## REFUSAL OF PLANNING PERMISSION

APPLICATION NO. 2017/1565

**Proposal** Erection of an annex to provide 2 no. respite care apartments

**At** The Gate, Barnsley Road, Dodworth, Barnsley, S75 3LE

Drawing Title
PROPOSED ELEVATIONS APARTMENTS

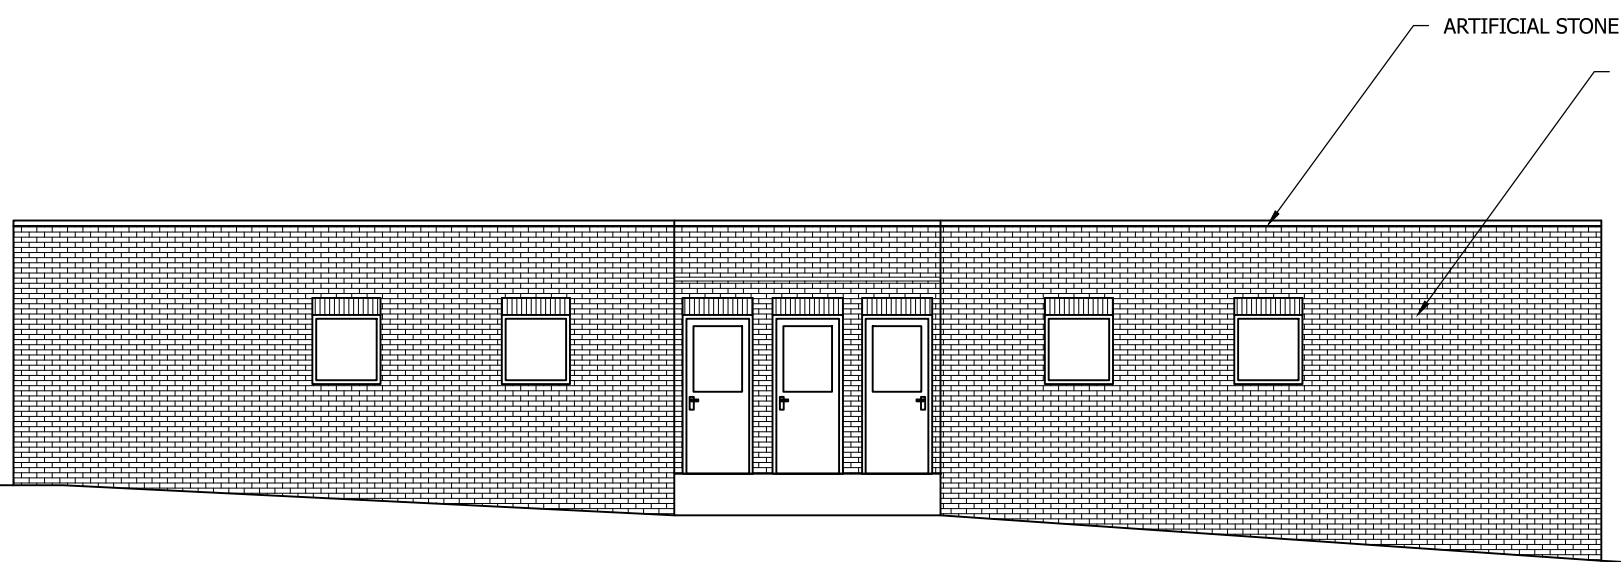
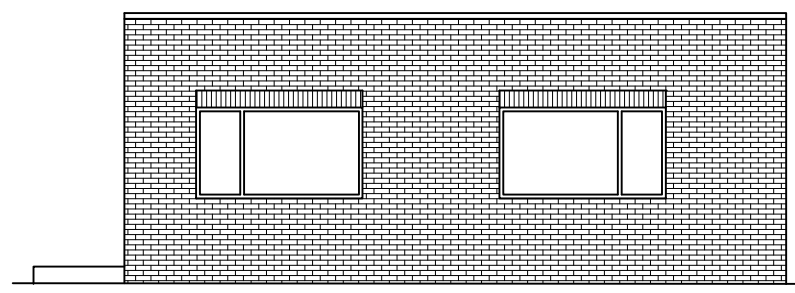
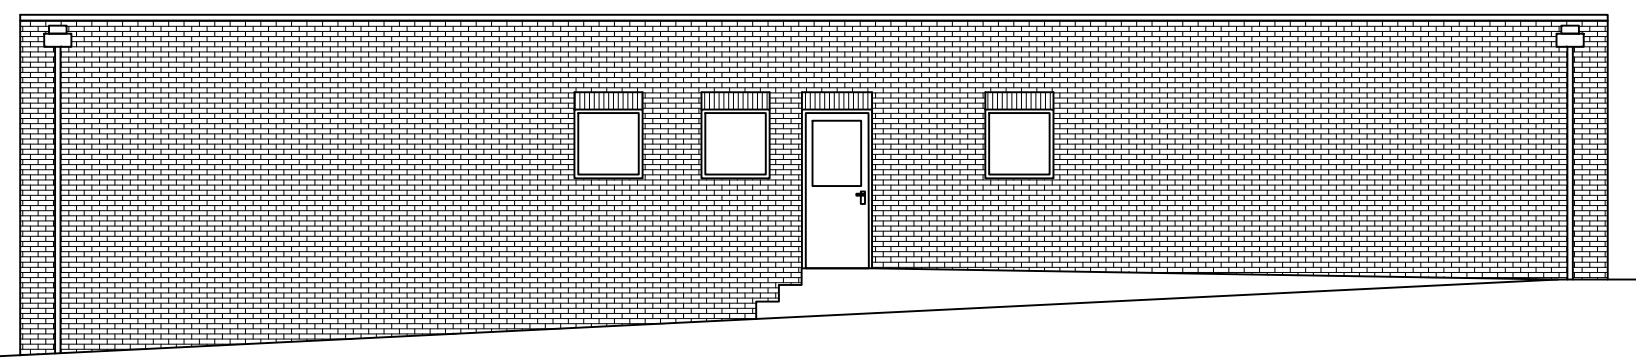
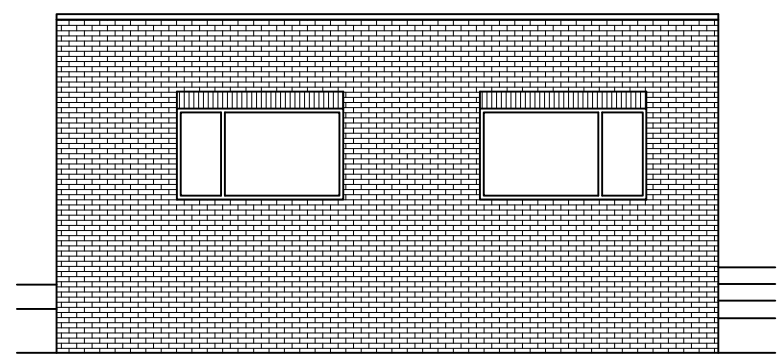
1	In the opinion of the Local Planning Authority the proposal would be an unsympathetic form of backland development that would appear incongruous and cramped in the context of the existing building and the surrounding area by virtue of its location, scale, mass and design features. As such the proposal is considered to be of poor design that would fail to improve the character and quality of the area and the way it functions which is contrary to Local Plan Policy GD1, Local Plan Policy D1, the Council's Supplementary Planning Documents (SPD) - Designing New Housing Development and paragraph 127 of the NPPF.
2	In the opinion of the Local Planning Authority the development would significantly reduce privacy levels, outlook and appear overbearing when viewed from the bungalow known as 'Breezeland' located immediately to the south as a result of its siting, scale and the change in levels. The proposal is therefore contrary to Local Plan Policy GD1 and the Council's Supplementary Planning Documents (SPD) - Designing New Housing Development.
